**CHENNAI METROPOLITAN DEVELOPMENT AUTHORITY**  
Thalamuthu Natarajan Building, No.1, Gandhi Irwin Road, Egmore,  
Chennai - 600 008  
Phone : 28414855 Fax: 91-044-28548416  
E-mail: mscmda@tn.gov.in  
Web site: www.cmdachennai.gov.in

**(Development Charges Letter)**

File No. : CMDA/PP/NHRB/S/0094/2020

**Sub:** CMDA-Area plans Unit - 'B' Channel (South) – Planning Permission application for the proposed construction of Stilt floor + 5 floors (18.30 m Height) Residential building with 45 dwelling units at Advocate Janakiraman Street, Muthulakshmi Nagar, Chittlapakkam, Chennai 600059 in S.No.163/6A1, 163/6A2, 163/7A & 163/7B of Chittlapakkam Village within the limit of Chittlapakkam Town Panchayat - Remittance of DC & Other charges – DC advice Sent - Reg

Site cum Stilt Floor Plan

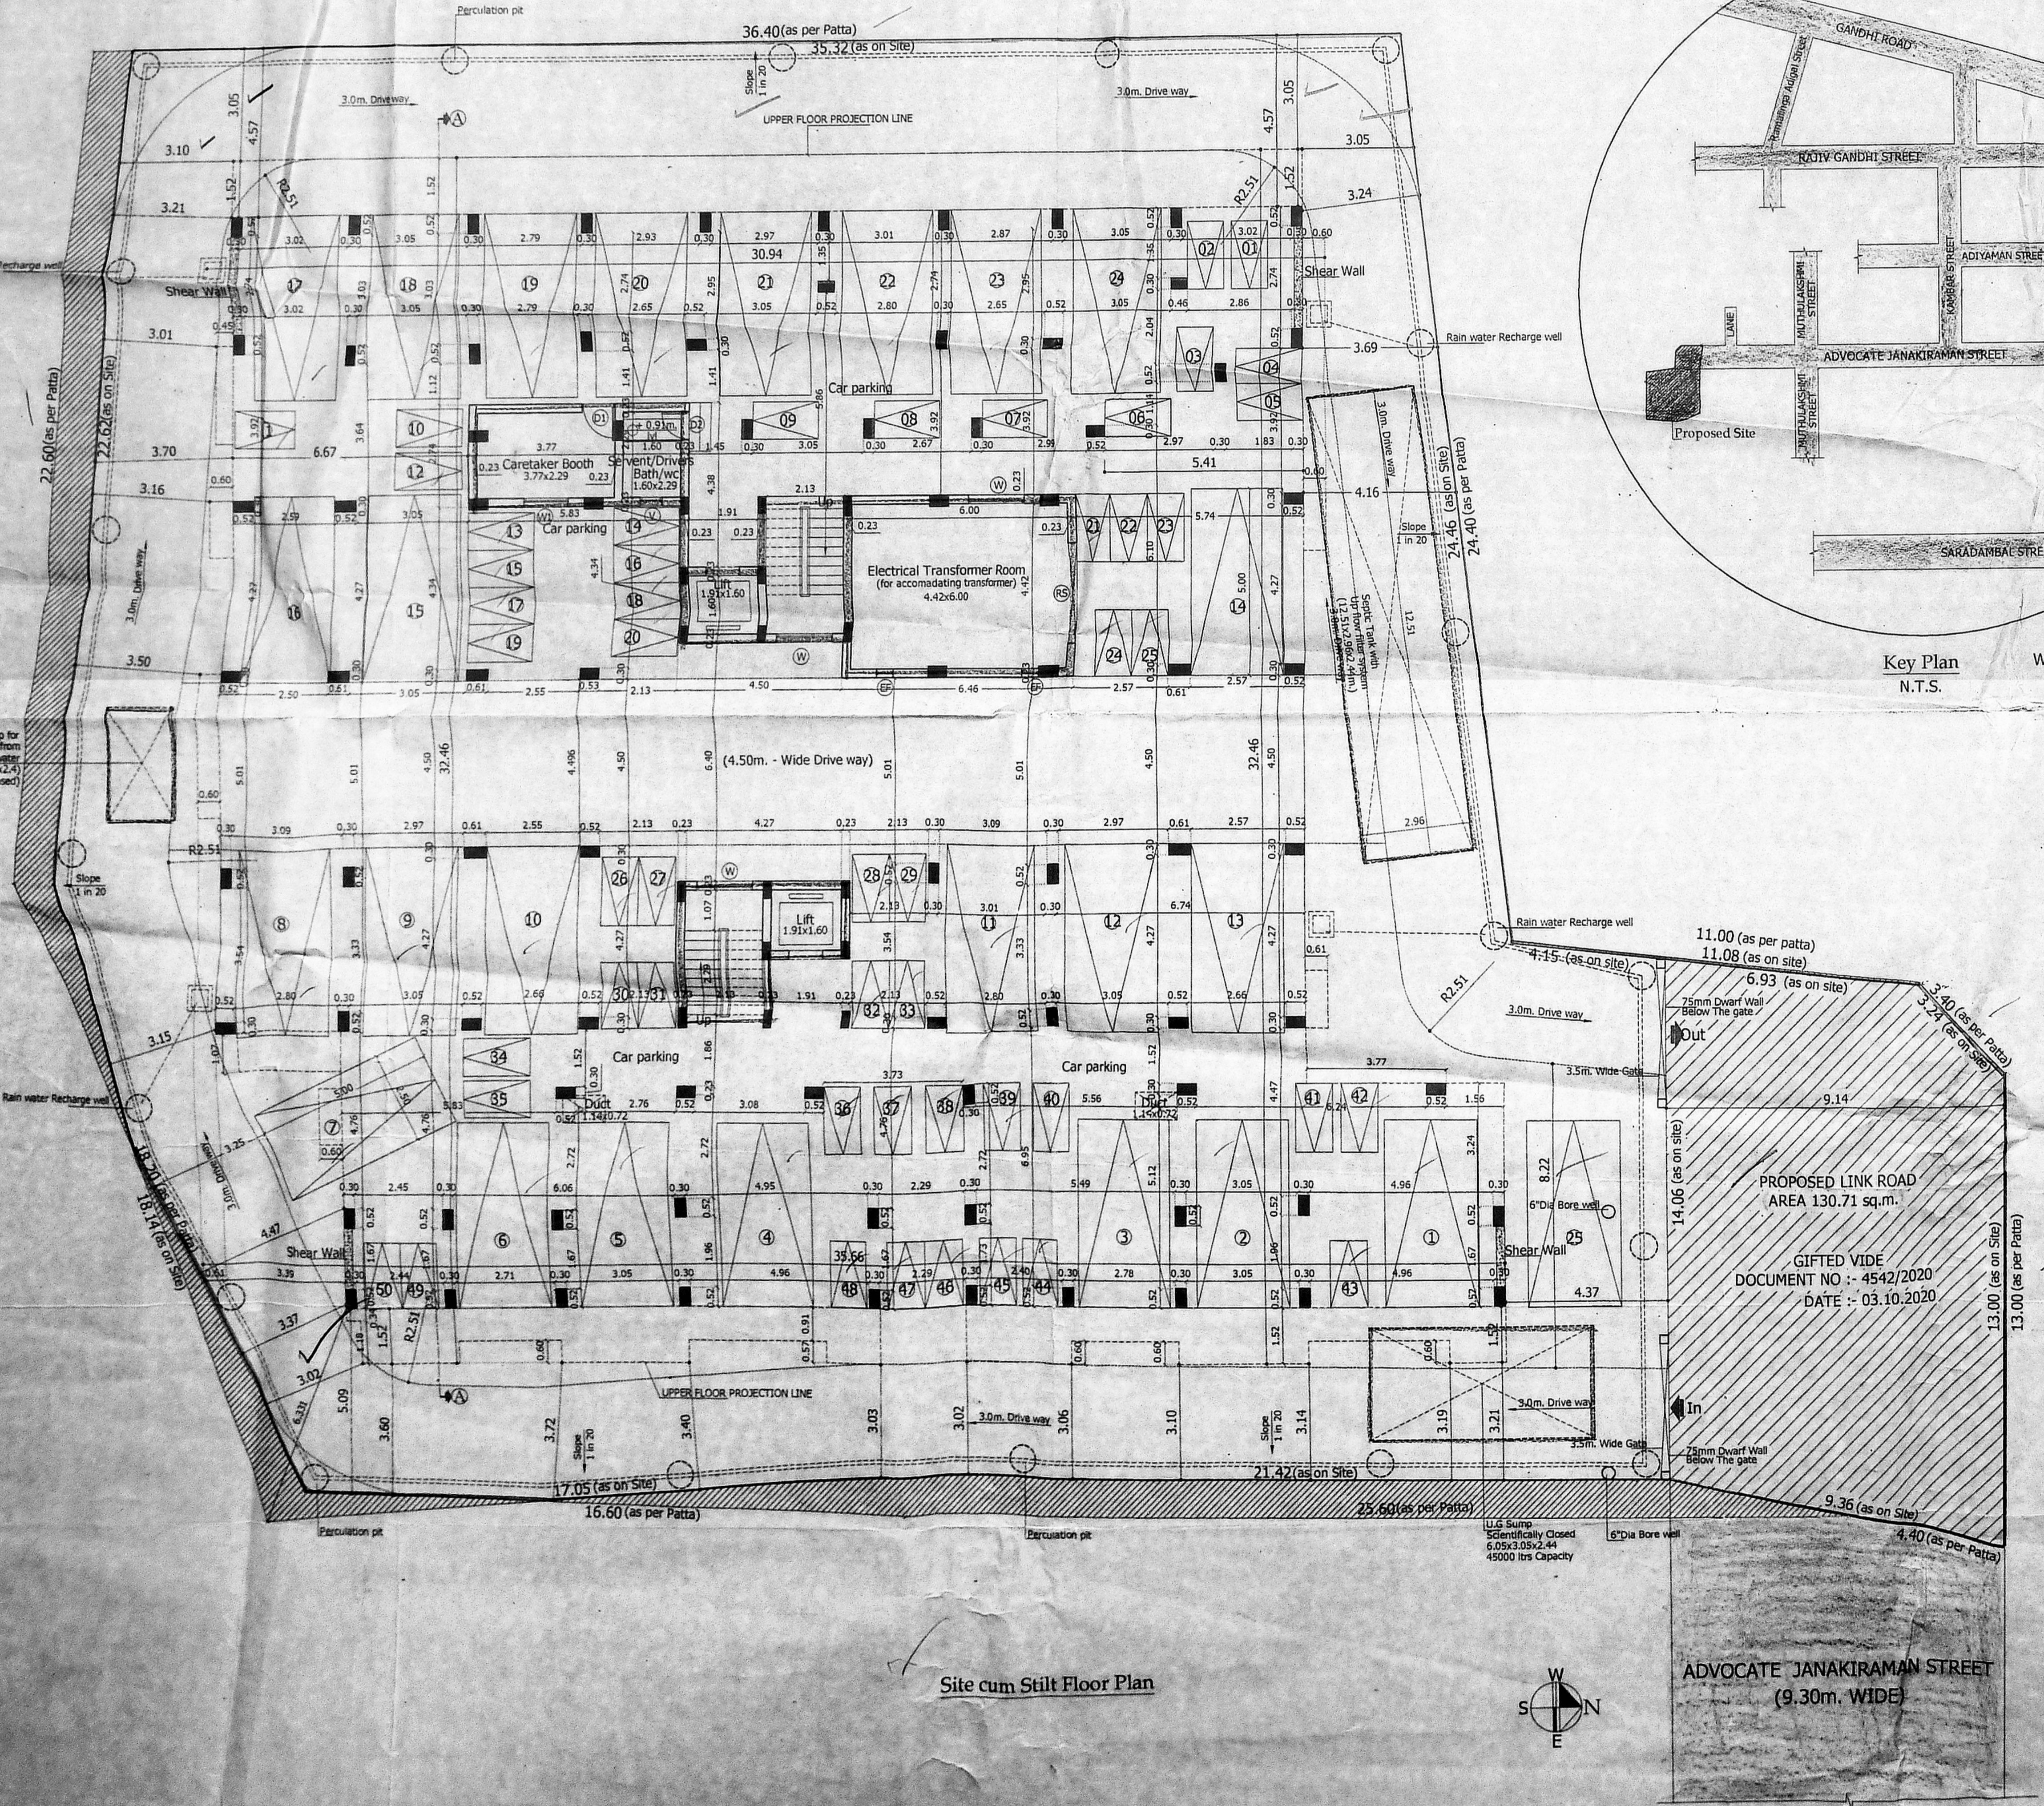
- Road width as per inspection observation to be shown in the site plan.
- Correct site boundary dimensions as on site to be shown.
- Electrical room to be renamed as Electrical Transformer room.
- Servants /Drivers Bath/WC to be shown as per TNCDBR.
- Sullage sump/OHT to be deleted
- Stilt floor to be shown in dotted line and stilt floor height from beam bottom to be shown in Section and Elevation.
- In site plan upper floor projection line to be mentioned.
- .Main title and area statement needs correction.
- In stilt floor wall shown near stair case and lift to be deleted.
- Rain water harvesting to be shown as per TNCDBR.
- Under Ground structures to be shown as dotted line.
- Link road portion to be gifted through a Registered Gift deed.
